Subject: Rezoning Petition Review

Rezoning Petition #: 21-092

Location of Property: Approximately 14.28 acres located on the south side of McDowell St, east of E Morehead and west of I-77.

TECHNICAL DATA
SHEET

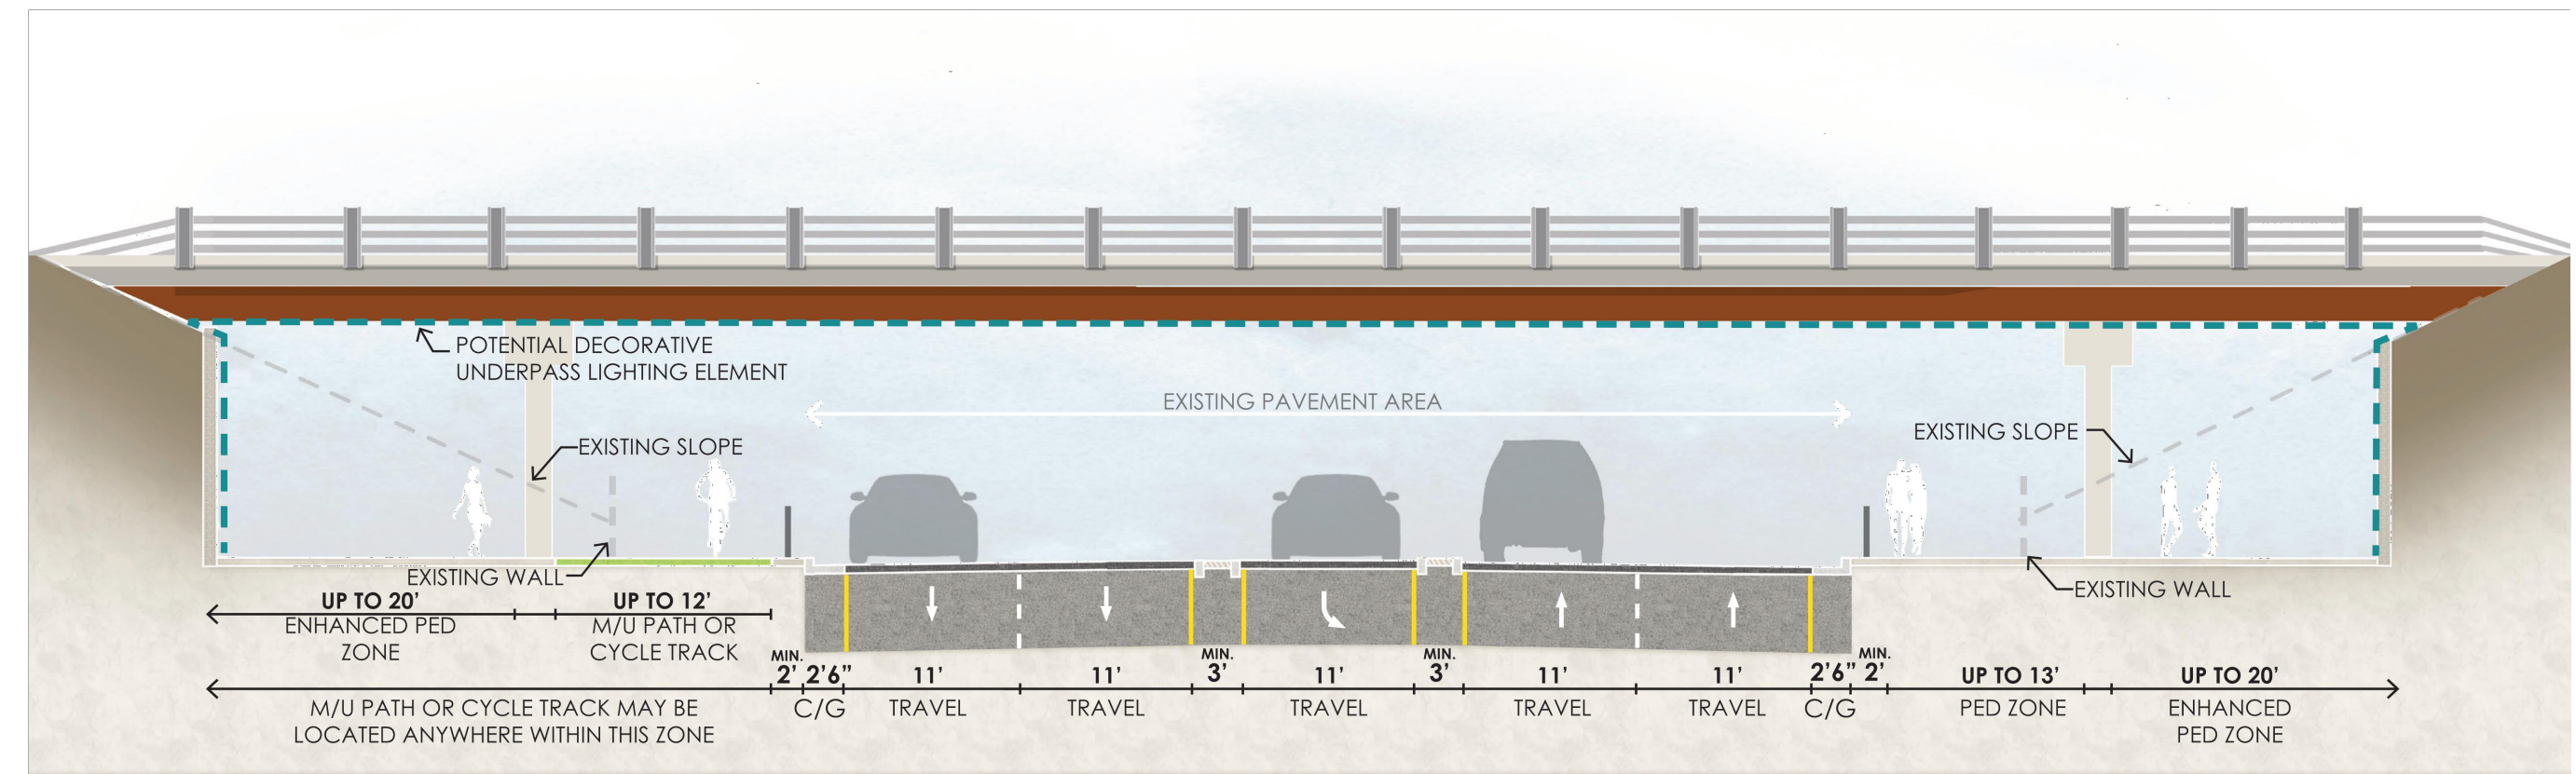
Please revise note 8A to read as follows: *The petitioner shall comply with the Charlotte City Council approved and adopted Post Construction Stormwater Ordinance.*

This property drains to Upper Little Sugar Creek, which is an impaired/degraded stream, and may contribute to downstream flooding. This project has the opportunity to mitigate future impacts to this stream, therefore, Storm Water recommends placing the following notes on the plan:

(I) Storm Water Quality Treatment

For defined watersheds greater than 24% built-upon area (BUA), construct water quality stormwater control measures (SCMs) designed for the runoff generated from the first 1-inch of rainfall for all new and redeveloped BUA associated with the project. SCMs must be designed and constructed in accordance with the Charlotte-Mecklenburg BMP Design Manual.

(II) Volume and Peak Control

For defined watersheds greater than 24% built-upon area, control the entire volume for the 1-year, 24-hour storm for all new and redeveloped BUA associated with the project. Runoff volume drawdown time shall be in accordance with the Charlotte-Mecklenburg BMP Design Manual.

For commercial projects with greater than 24% BUA, control the peak to not exceed the predevelopment runoff rates for the 10-yr, 6-hr storm and perform a downstream flood analysis to determine whether additional peak control is needed and if so, for what level of storm frequency, or if a downstream analysis is not performed, control the peak for the 10-yr and 25-yr, 6-hour storms.

For residential projects with greater than 24% BUA, control the peak to not exceed the predevelopment runoff rates for the 10-year and 25-year, 6-hour storms or perform a downstream analysis to determine whether peak control is needed, and if so, for what level of storm frequency.
